SUBJECT: Engineering Review Comment
Mountain View Electric Association Inc. (MVEA)

Project Name: Berkheimer Subdivision Filing 1 – Final Plat

Project Number: SF2433

BERKHEIMER SUBDIVISION FILING NO. 1

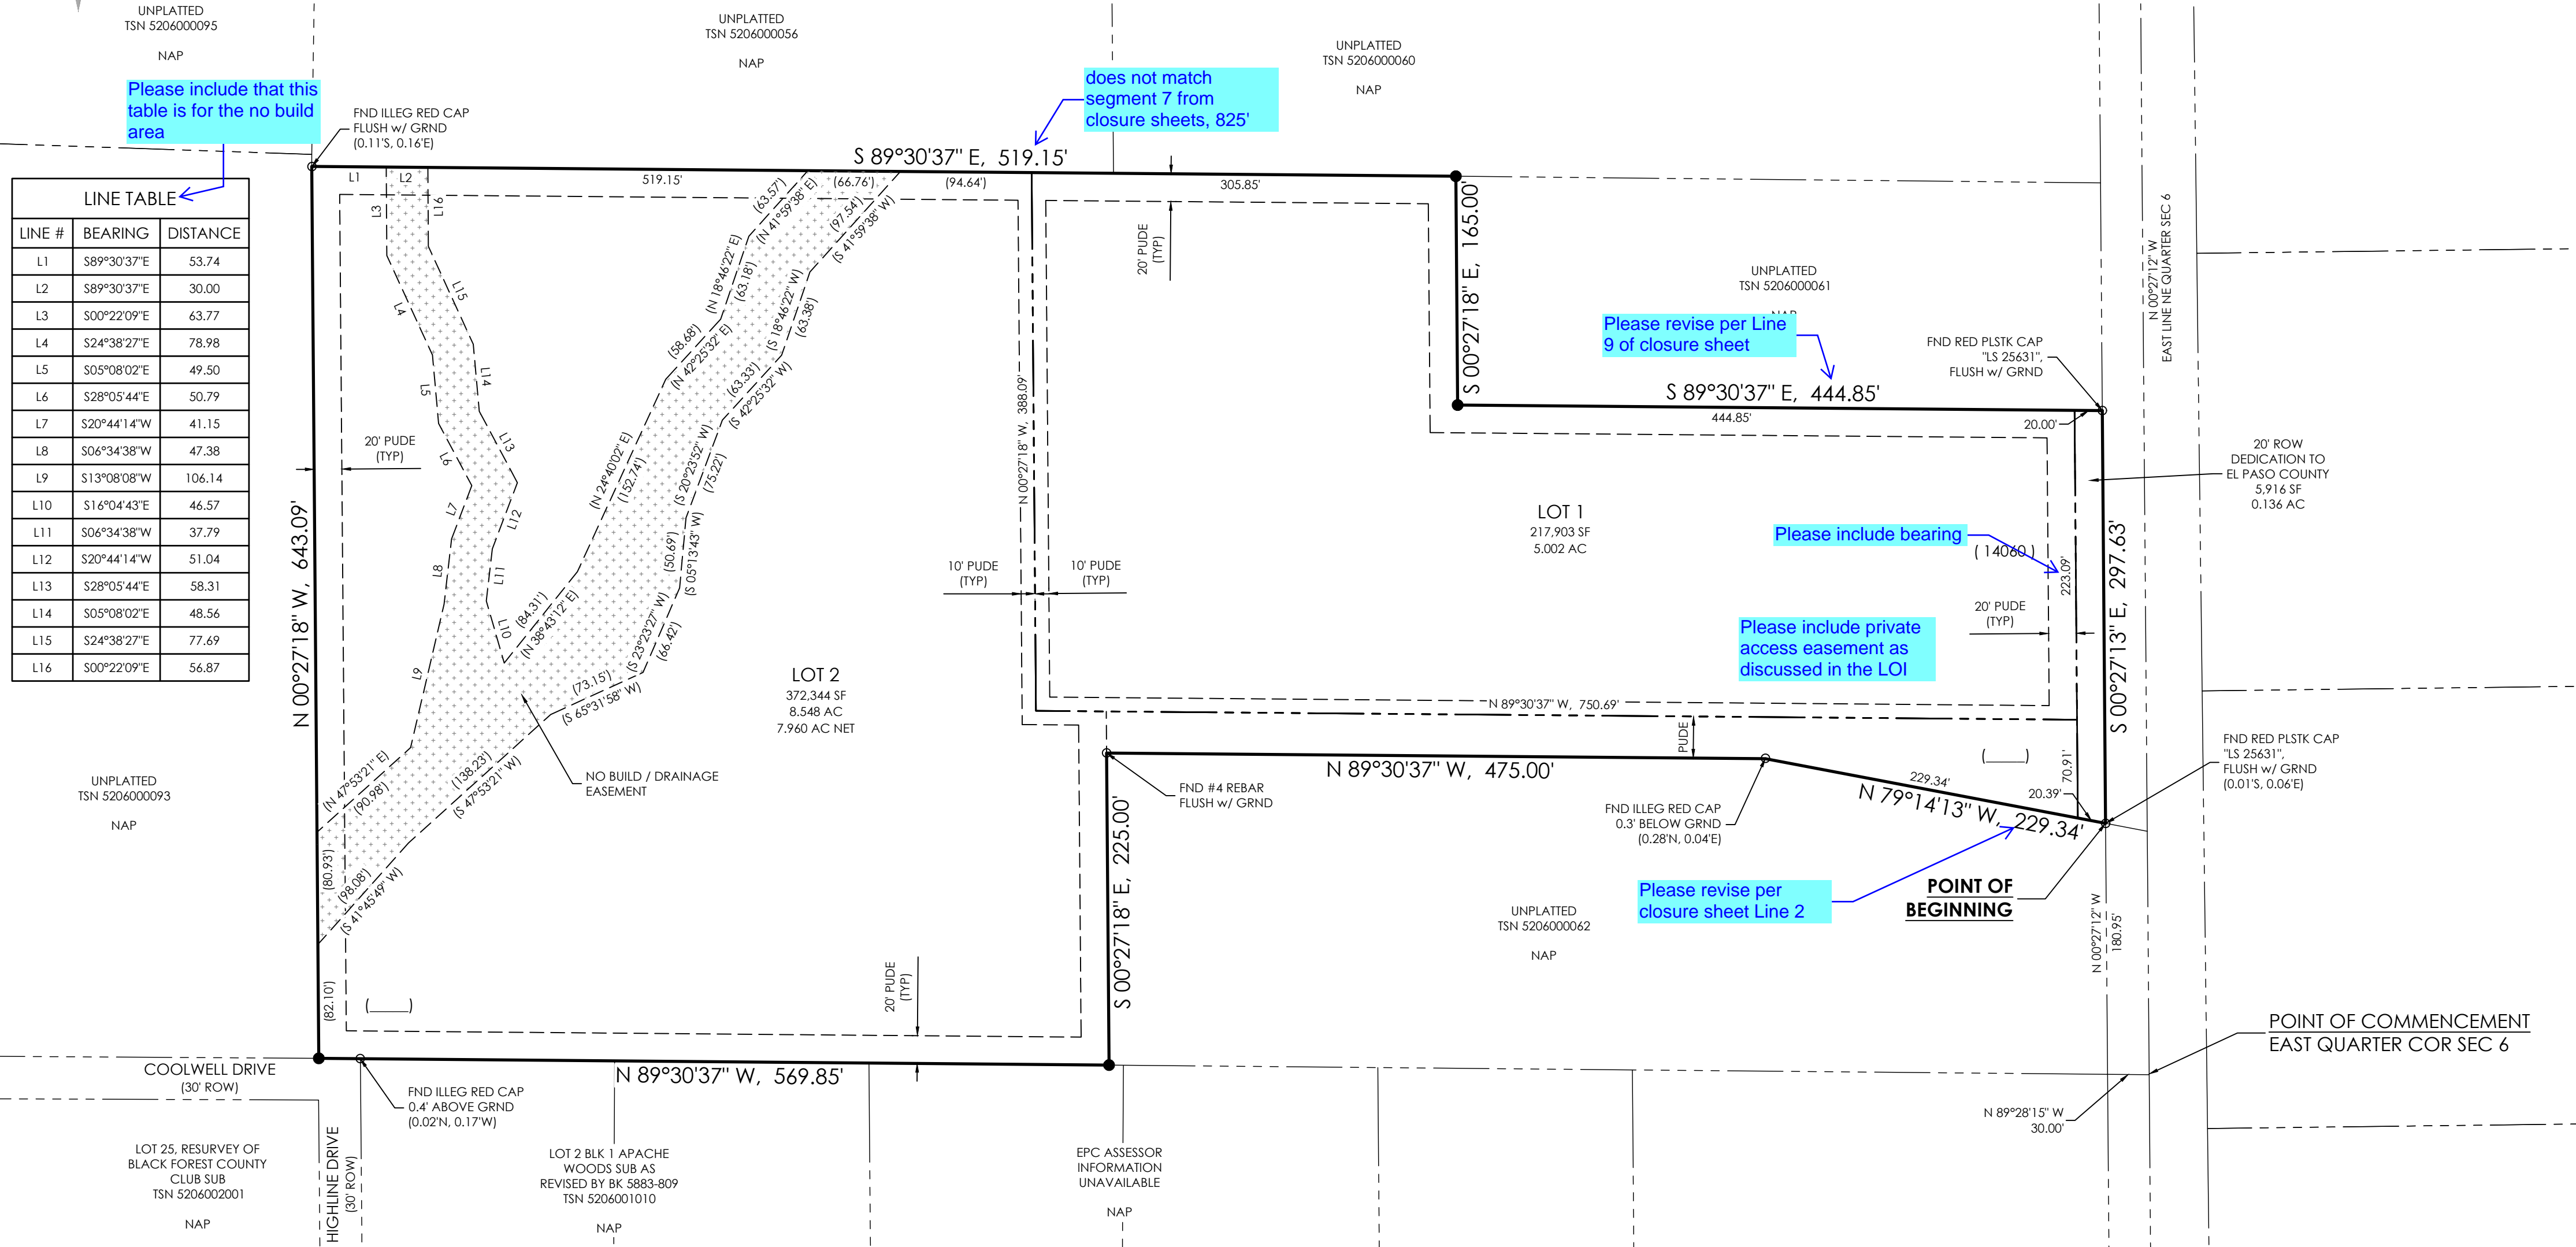
MVEA requests a ten (10) foot front, side, and rear lot utility easement and all tracts, along with a twenty (20) foot exterior utility easement on the plat. MVEA also requests the platting of MVEA's existing facilities with easements on the plat. Additional easements may be required.
